Re: response to PA Opinion/Tri-partite Meeting

Drawing: Landscape
Layout 001

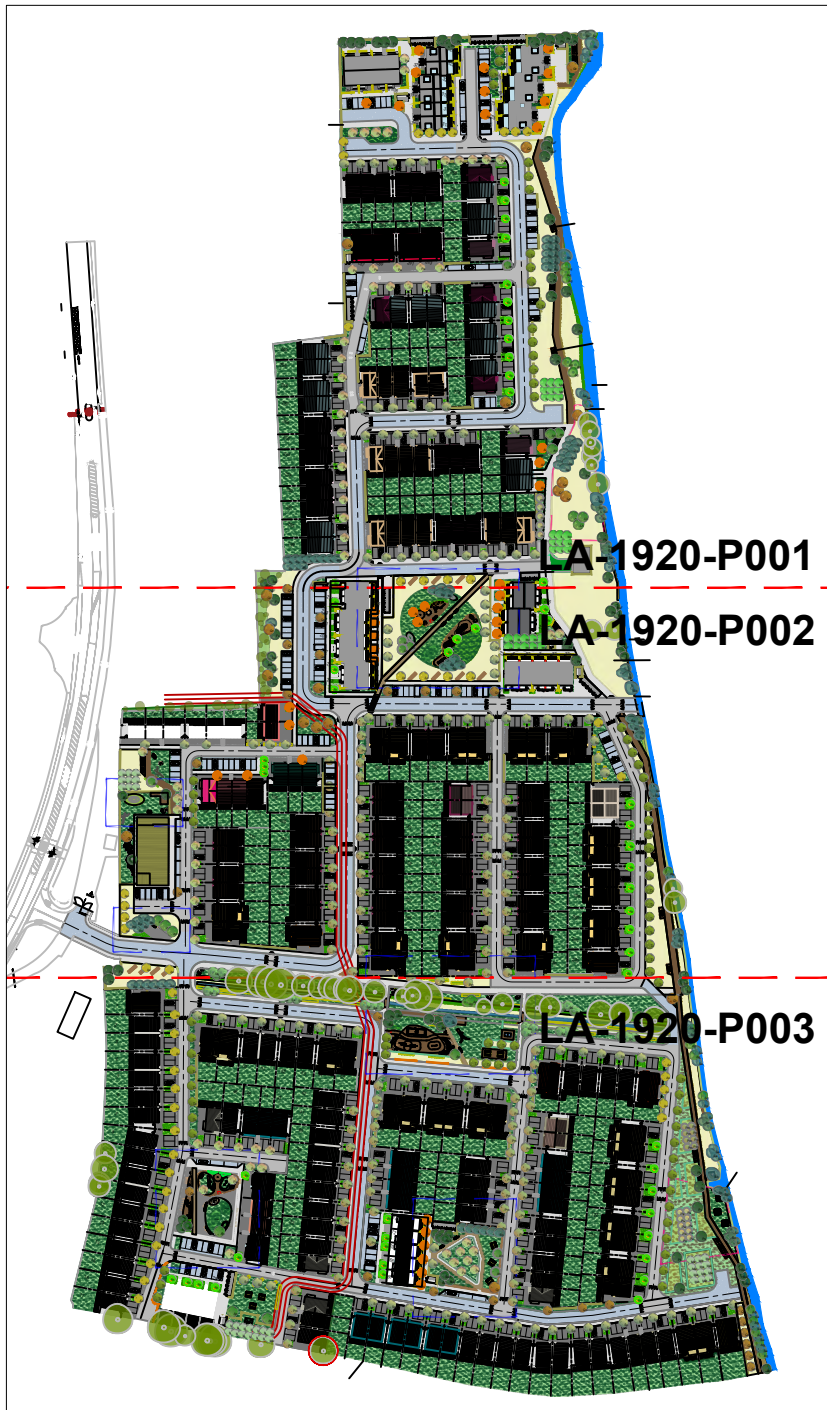
Improved landscaping is required on the southern boundary

Improved green zone buffer with more intense soft landscaping where side boundary walls face main thoroughfares, adjacent to units 121-140 & 149 – 175 to better disguise exposed boundary walls.

- Additional landscaping has been proposed to the southern boundary, refer to Landscape plan.

- Additional landscaping has been provided adjacent to side boundary walls to soften and disguise exposed walls. Refer to Landscape Plan

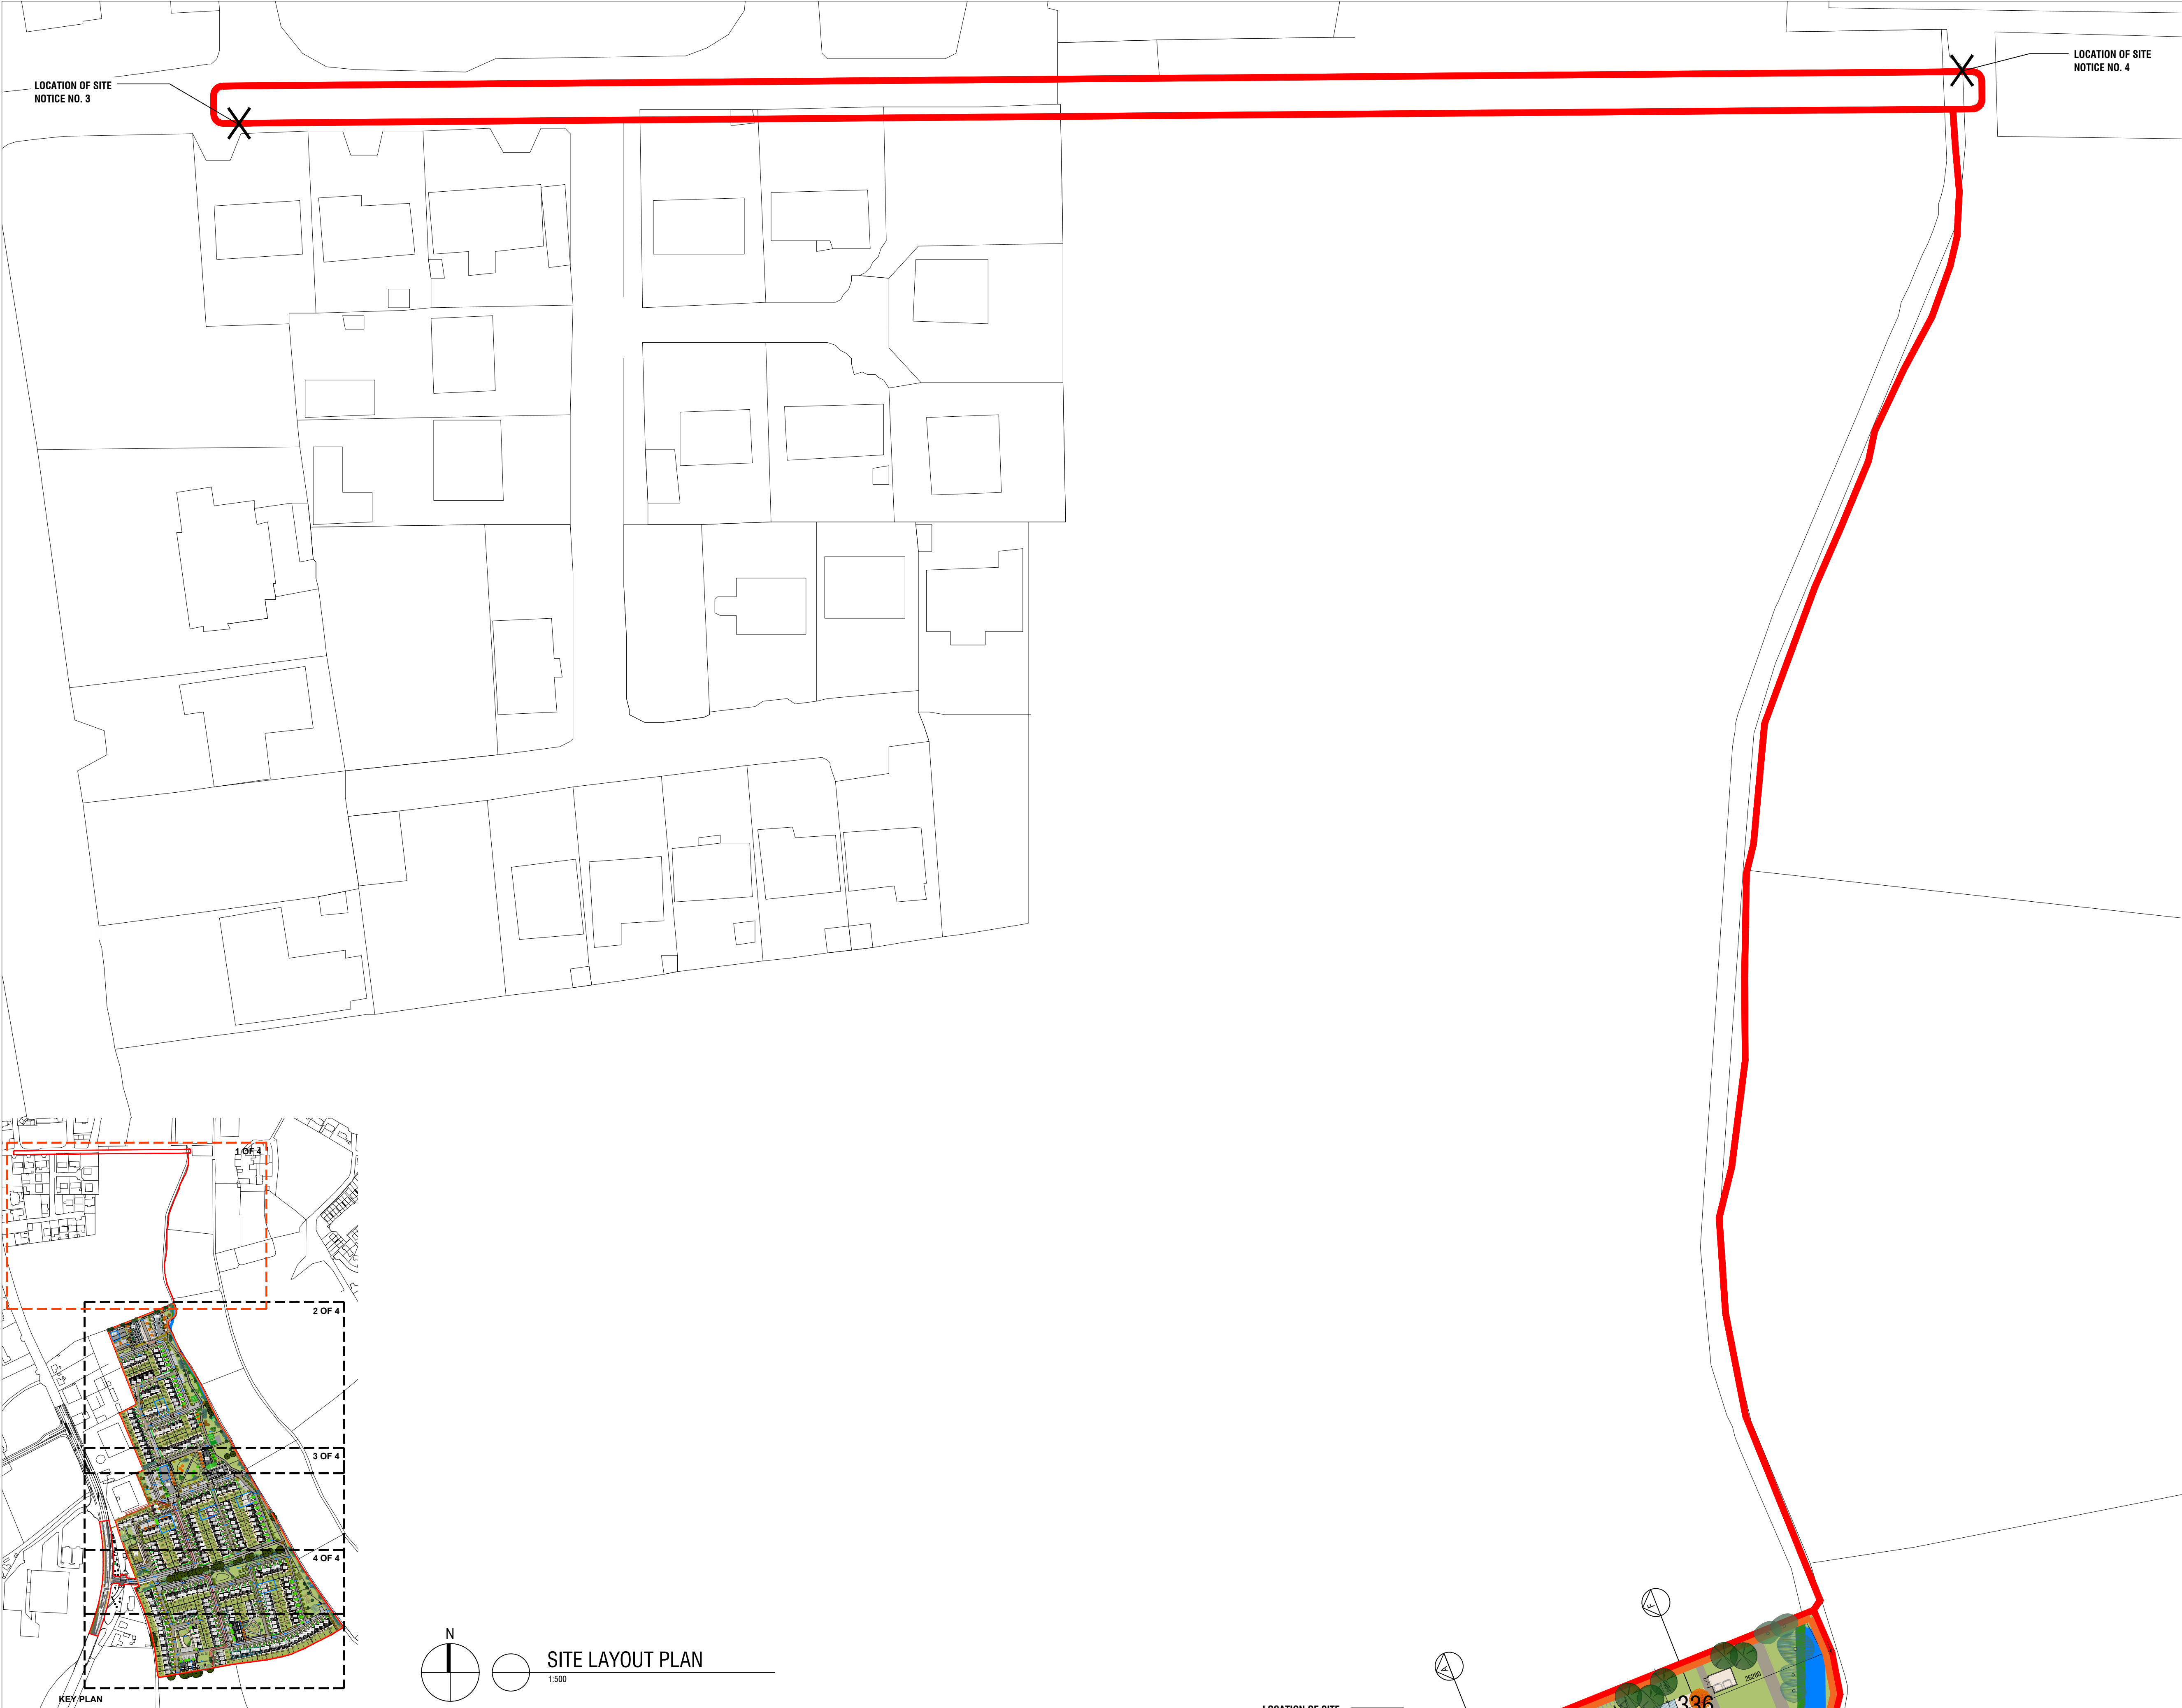
The location of parking for dwelling 27 – 30 needs to be identified

Parking for apartments 353 – 374 needs to be clarified

Location of bicycle racks opposite 314 – 336 needs to be considered

- Car parking for these units is located the south of the open space adjacent to the public open space.

- These units have been replaced. Every house has 2 car parking spaces. Almost all car parking spaces for the housing are located within the site curtilage. Any car parking for housing not located within the site curtilage is numbered on the Site Plan. Car parking for the duplex units is also numbered and clearly identified on the Site Plan.

- Bicycle racks have been dispersed throughout the scheme, proximity to the residential units and overlooking/passive supervision of the racks has been considered. Specifically, racks have been added in front of 218, 220, 237, 238, 222,224,332,334 & 336

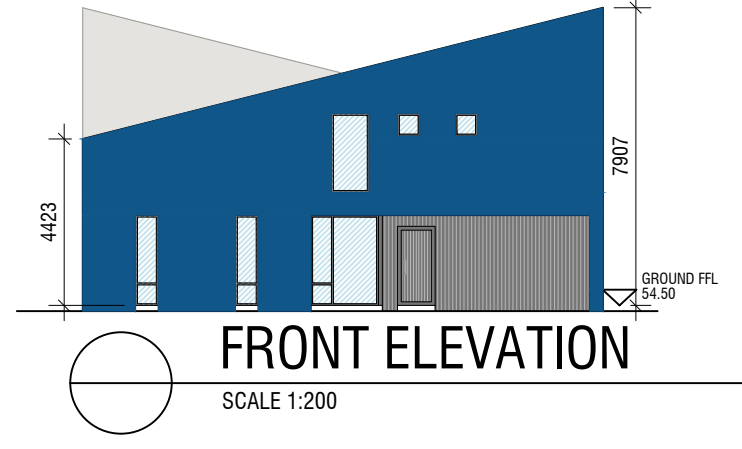
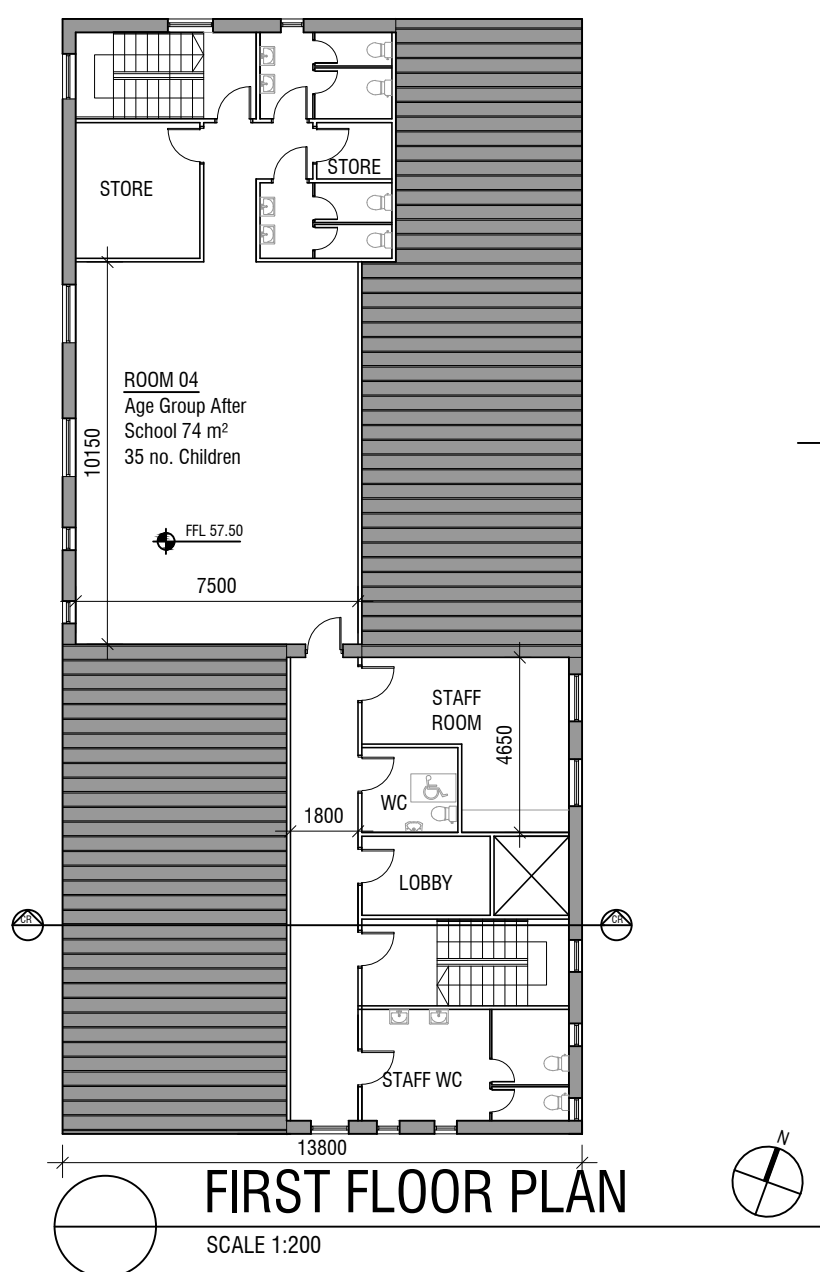
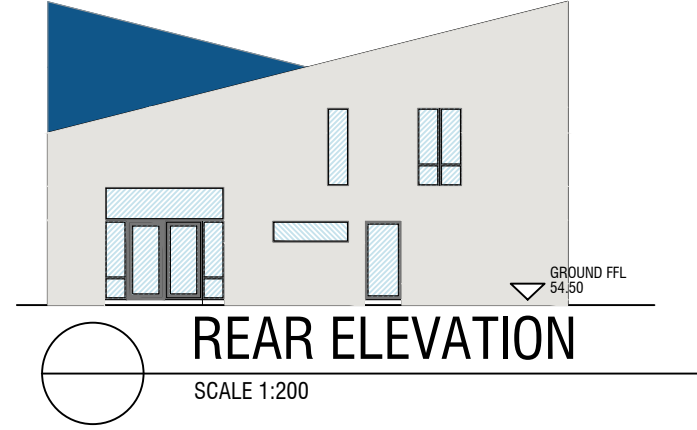
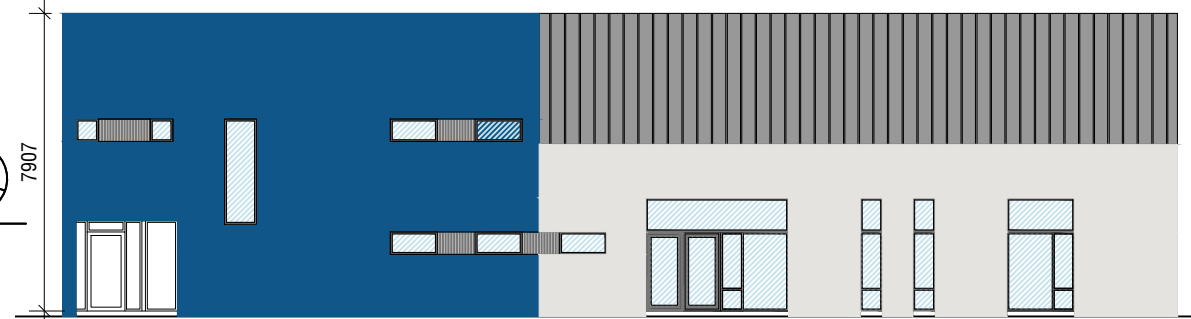
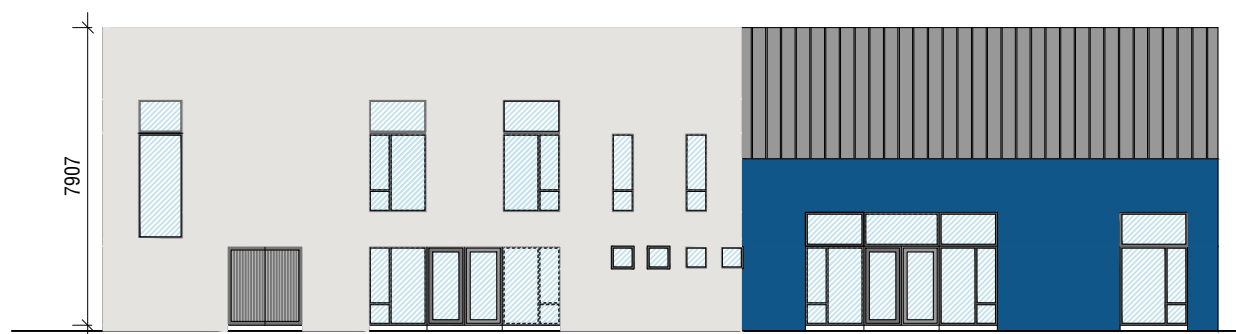
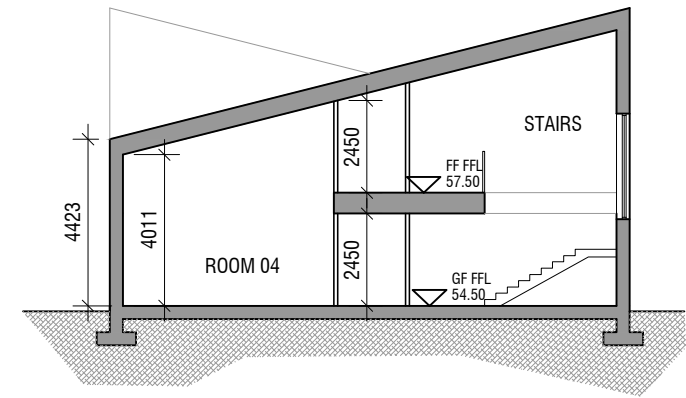
It might be noted that the Explanatory Guide to the Child Care (Pre-School Services) Regulations, 1996, recommends as follows:

<i>AGE OF CHILD</i>	<i>FLOOR AREA PER CHILD</i>
<i>0 – 1</i>	<i>3.70 m²</i>
<i>1 – 2</i>	<i>2.80 m²</i>
<i>2 – 6</i>	<i>2.32 m²</i>

These recommendations relate to clear floor space per child. Extraneous areas such as kitchens, toilets, sleeping and other ancillary areas are deemed to be separate.
